6 November 2013

***Modification Request for the University of Sydney Abercrombie Precinct
Redevelopment: Application Number: MP07_0158 MOD 3***

1 GROUND FLOOR PLAN
SCALE 1:200 @ A1

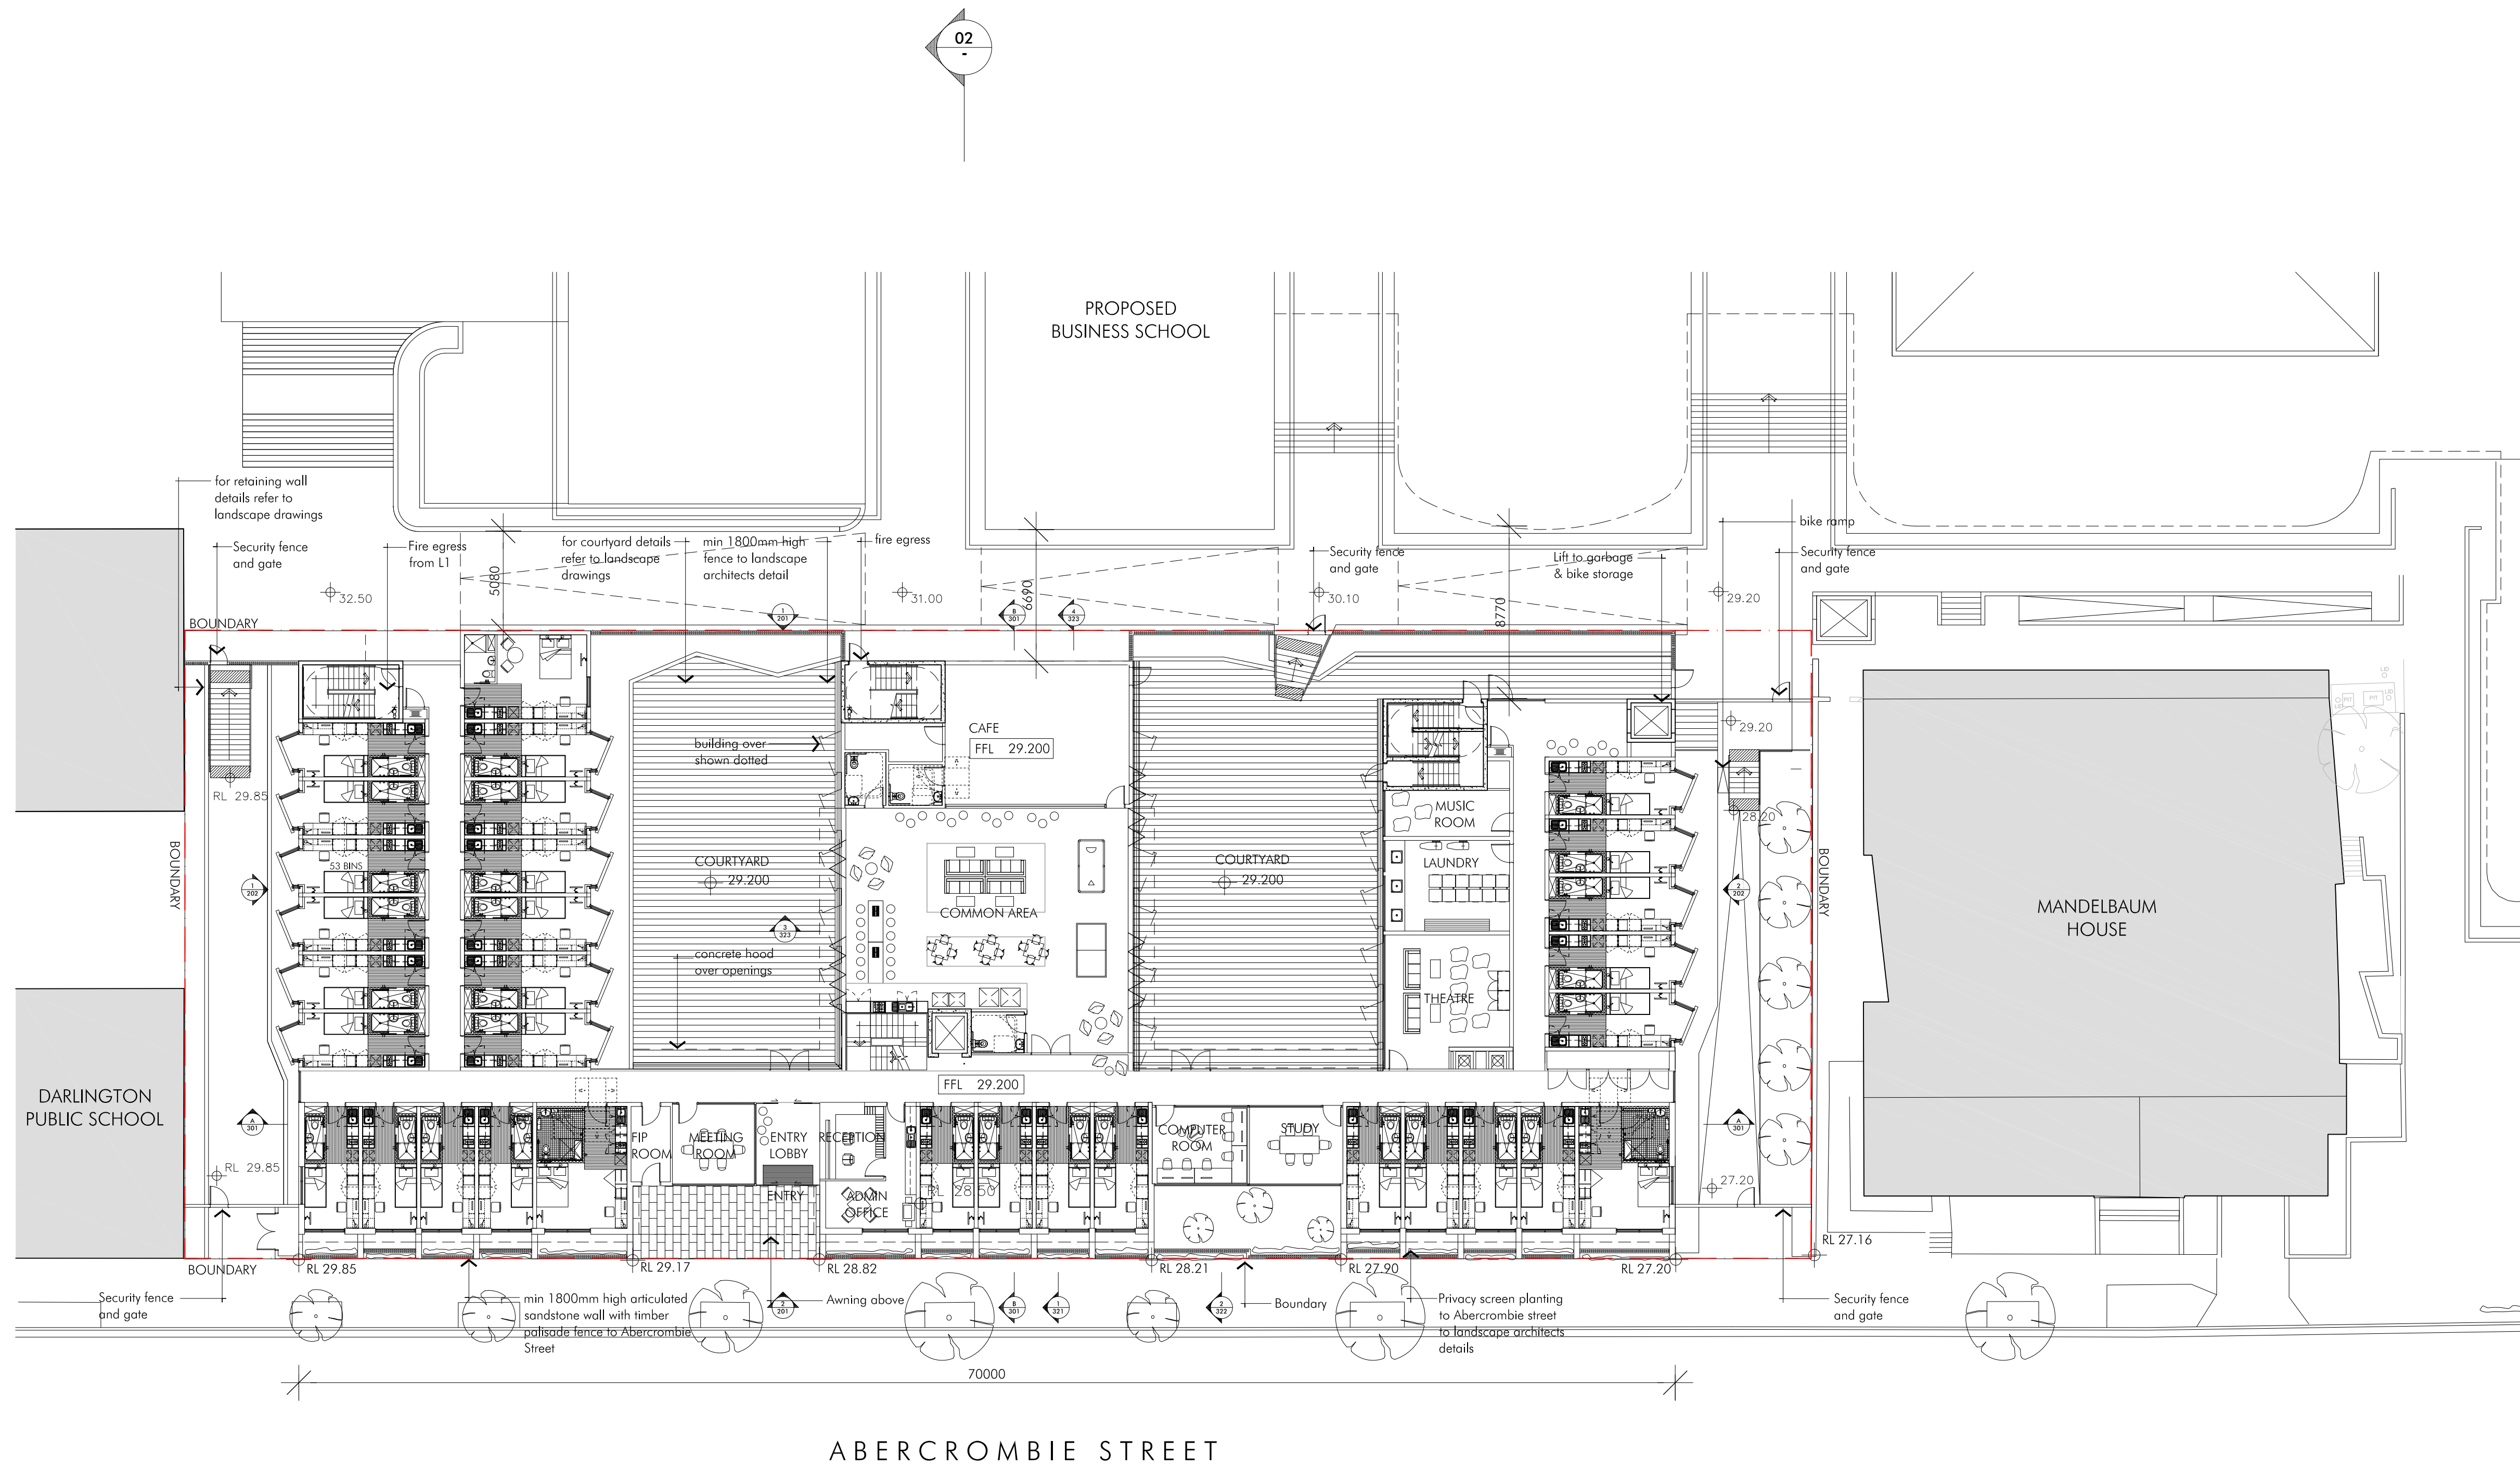
- The front of the Student Accommodation building should be built 2 metres back from the Abercrombie Street boundary. It should be set back from this boundary so that it is in line with Mandelbaum House as it was originally planned and presented to the community. The footprint of the buildings currently on the site, The Shepherd Centre and Boundary Lane Children's Centre, were built approximately 2 metres back from the Abercrombie Street boundary and align with Mandelbaum house. Therefore, the front footprint of the proposed Student Accommodation building should be the same as those buildings occupying the site at present and not be built up to the Abercrombie street boundary.

- The facade of the proposed Student Accommodation building does not reflect the heritage appearance of the Victorian terraces on Abercrombie Street as Mandelbaum House does. Therefore, it should be set back to allow for extensive vegetation and trees to be planted in front of the building on Abercrombie Street to help preserve the heritage streetscape and improve both the aesthetics and the environment of the street.
